MP10_0048 - Headland Park and Northern Cove - Main Works

PUBLIC COMMENT ON DEVELOPMENT APPLICATION

Submission to the NSW Department of Planning 09 December 2010

Main works for the creation of the Barangaroo Headland Park and North Cove, including:

**MAIN WORKS APPLICATION
CARPARK & FUTURE CULTURAL FACILITY
PLAN RL 25.0**

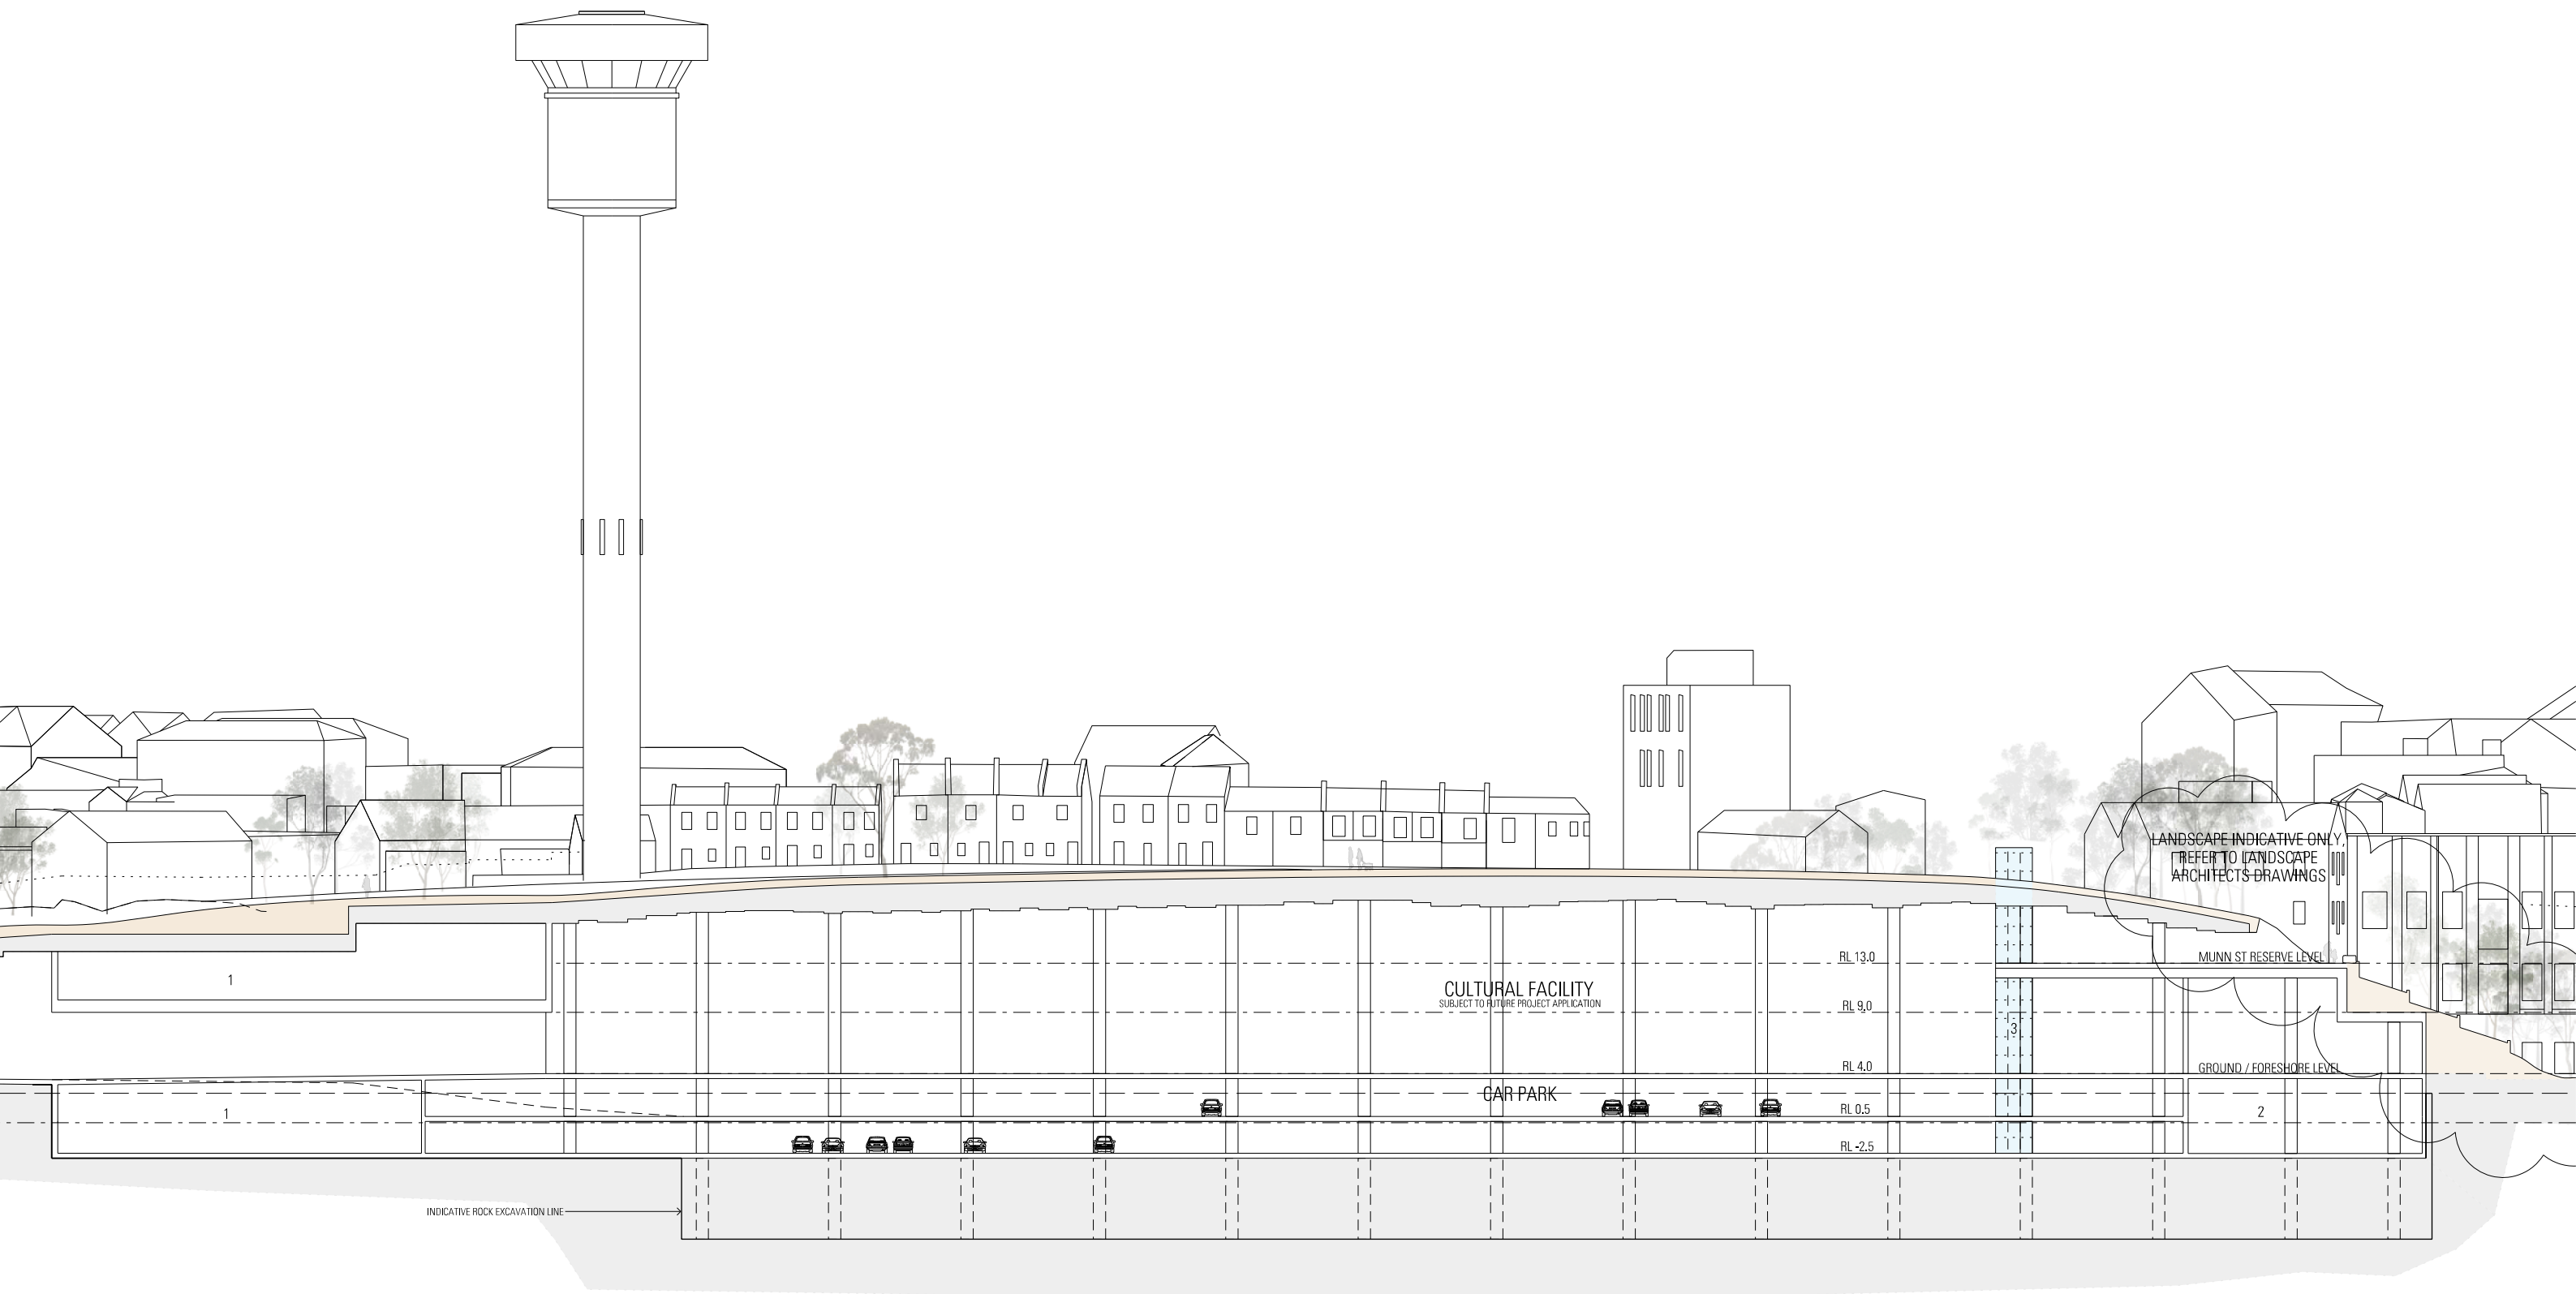
- i. The idea of a car park underneath this space as an entry experience to a park is problematic.
- ii. The 'slot' entrance to the car park is very ungenerous.
- iii. There is only a single lift area servicing 300 car places, a 3 story cultural facility and the main entry to the park for less mobile people.
- iv. 'The most likely users (*of the car park*) would be visitors to the area for leisure activities in the park, or to cycle or walk along the foreshore' (Headland Park And Northern Cove Main Works Environmental Assessment, P. 88).

We find it difficult to imagine all of these users being served by a single lift entrance.

MAIN WORKS APPLICATION CARPARK & FUTURE CULTURAL FACILITY CARPARK VENTILATION

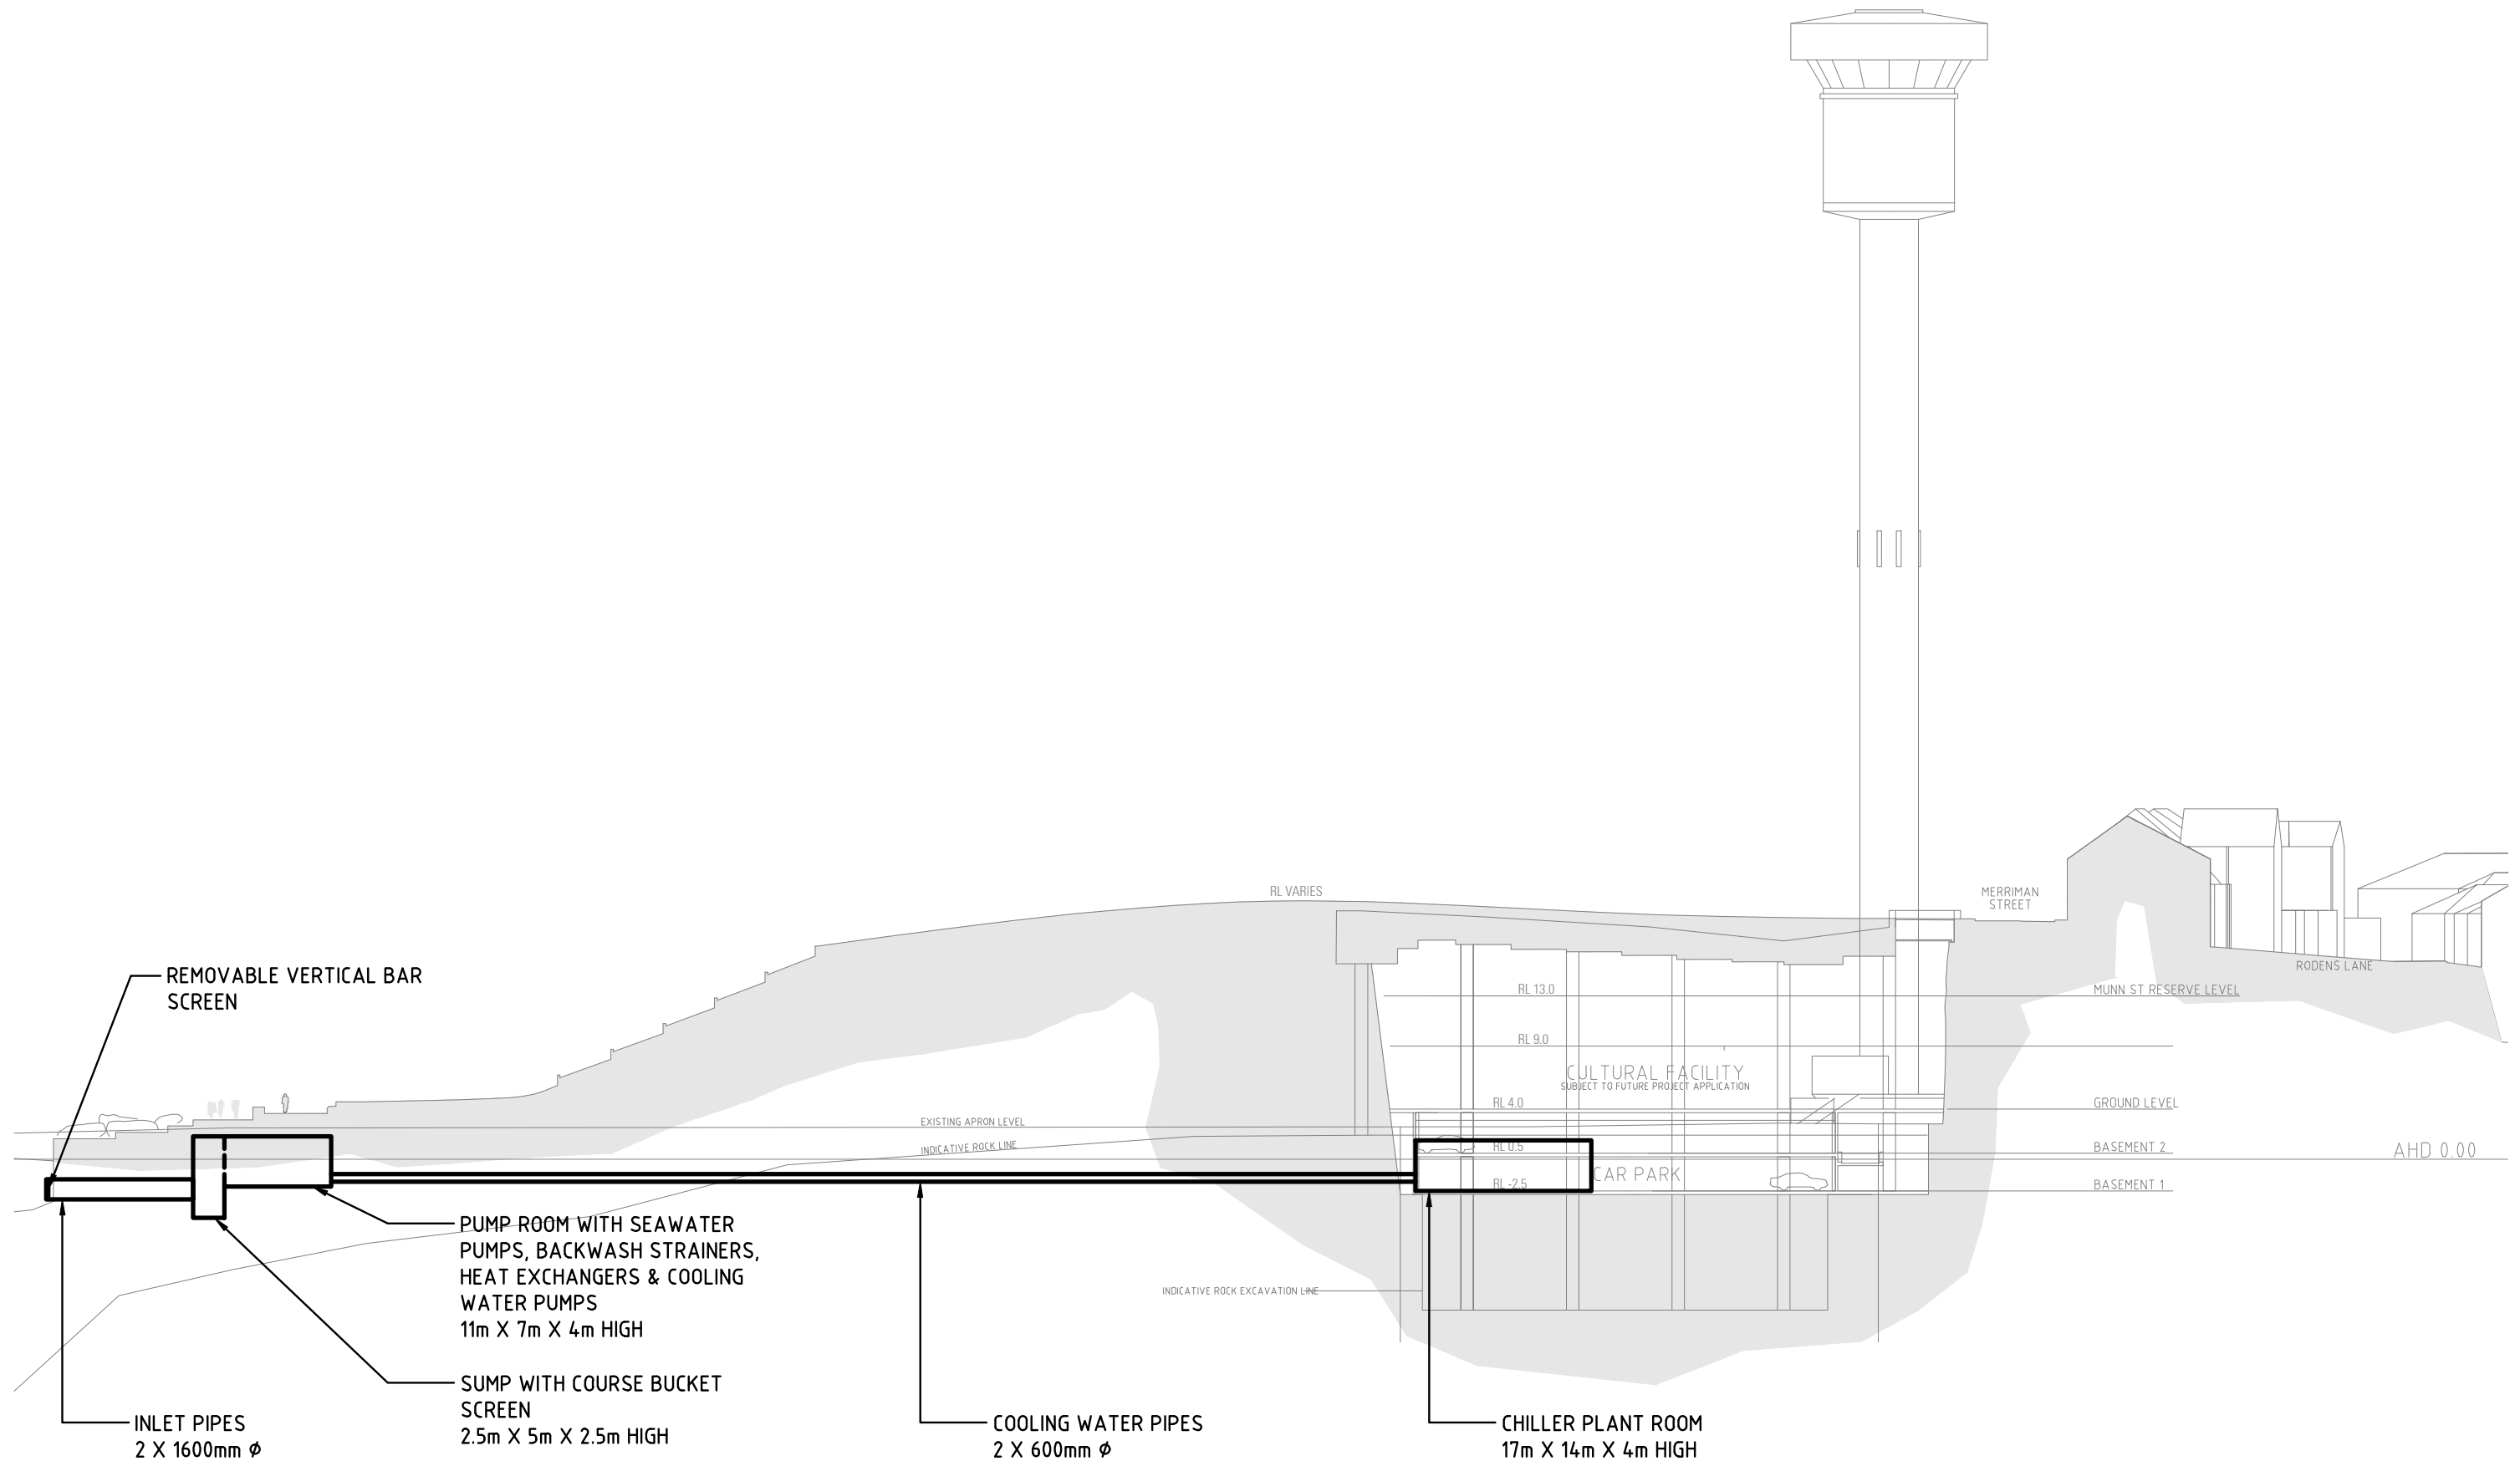
- v. 'The basic intent of the cultural space is to express the morphology of the sandstone headland by leaving the sandstone cliff exposed similar in manner to the existing wall in The Bond building on Hickson Road. This will create a space with the potential to provide a venue as evocative as the Tate Modern's Turbine Hall or (locally) the Cockatoo Island halls.' (Headland Park And Northern Cove Main Works Environmental Assessment, P. 51)
- vi. Western air plenum (Headland Park And Northern Cove Main Works Environmental Assessment, P. 61)

How does the air get out? Releasing car park fumes into parkland? No reference to emission rates in the 'Air Quality and Health Assessment'. Where are the vents for a 5 story building?
